Planning Officer: Ms Myer

Planning Application Ref: BN/114/21/PL

Location: Land to rear of Highground House & Orchard End, Highground Lane, Barnham

Description of works: Creation of 1no. 1.5 storey dwelling on brownfield (previous use commercial car parking / children's play area associated with holiday let business) (resubmission following BN/53/21/PL). This application is a Departure from the Development Plan & is in CIL Zone 3 & is CIL Liable as new dwelling.

project	Land north of Orchard End Highground Lane Barnham
client	Mr & Mrs M Bates	title	Tree Constraints Plan
dwg	BJH 01/02	scale	1:500 @ A3
date	July 2021	job	2003
drawn by	bjh	The Granary - White Chimney Row - Westbourne PO10 8RS 07875 520881 bernieharverson@gmail.com

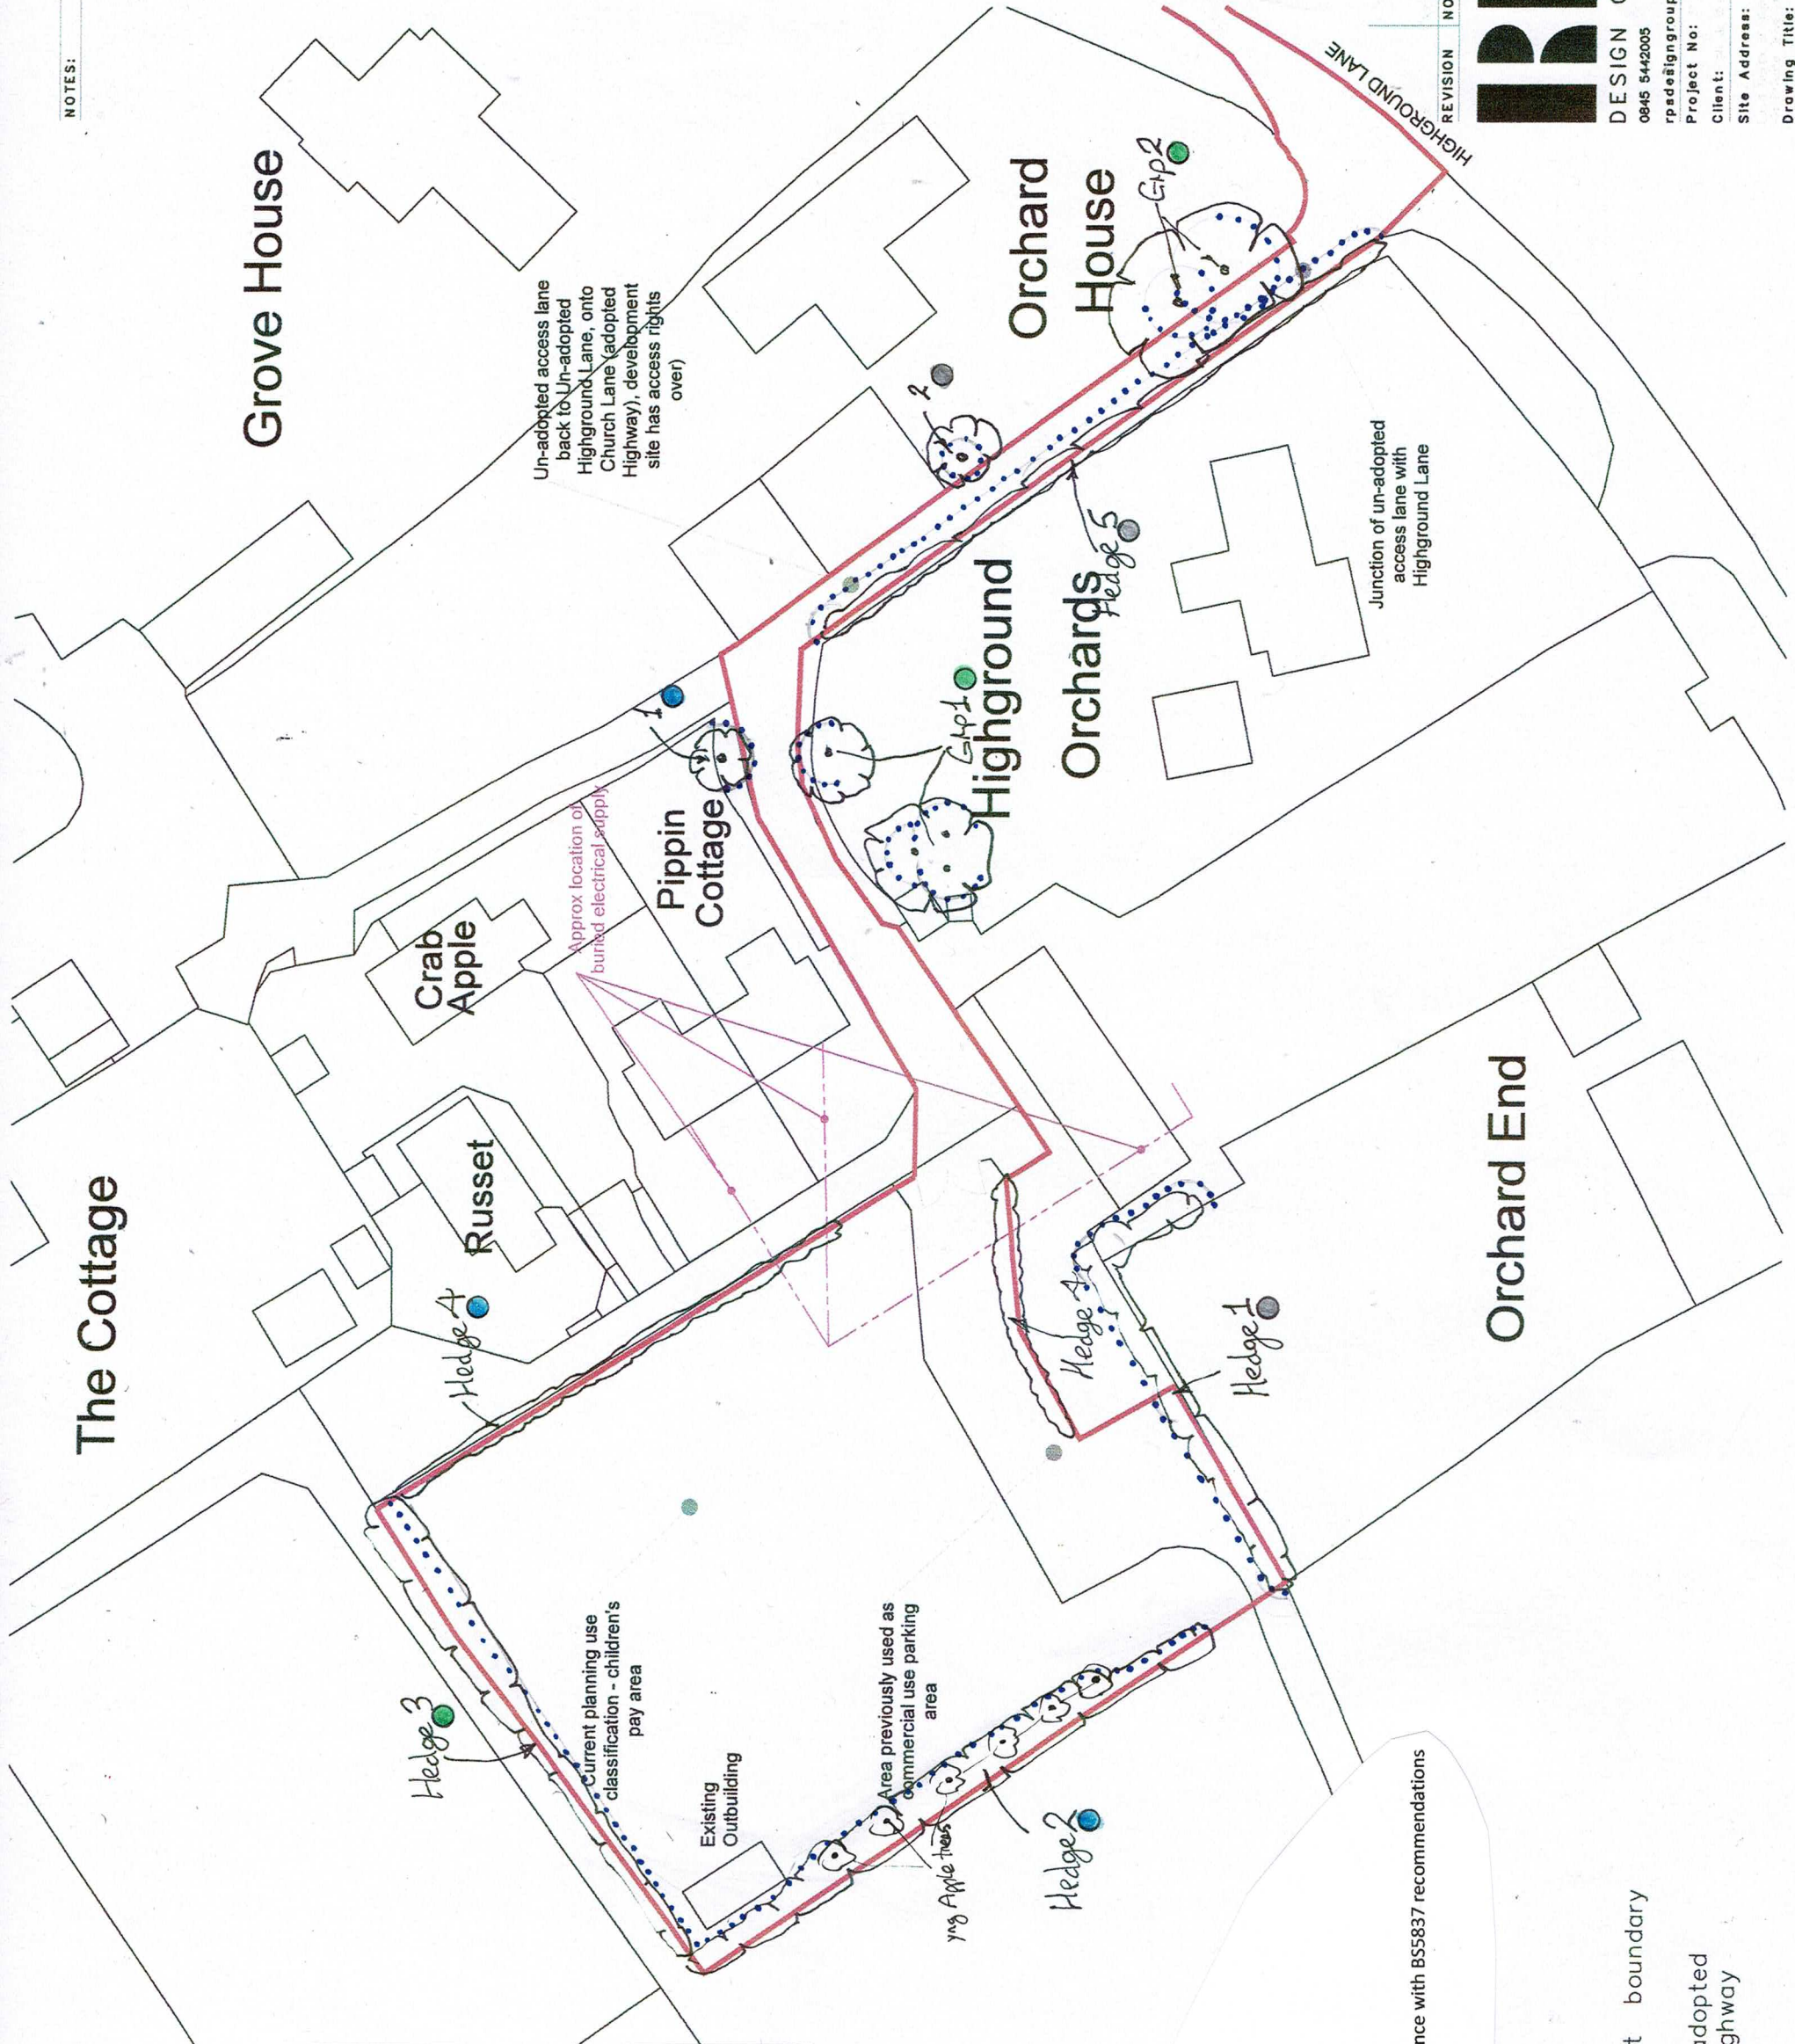
1. Before the site is occupied or any machinery is introduced to the site or demolition work or construction work or alterations to existing ground levels takes place, written confirmation is required from the Arboricultural Expert representing the site owner(s), confirming that all protective fencing has been inspected and found to be 'Fit for Purpose' as required under British Standard 5837:2012 and been erected and positioned exactly as shown on the **Tree Protection Plan, dwg no. BJH 03/04, July 2021**
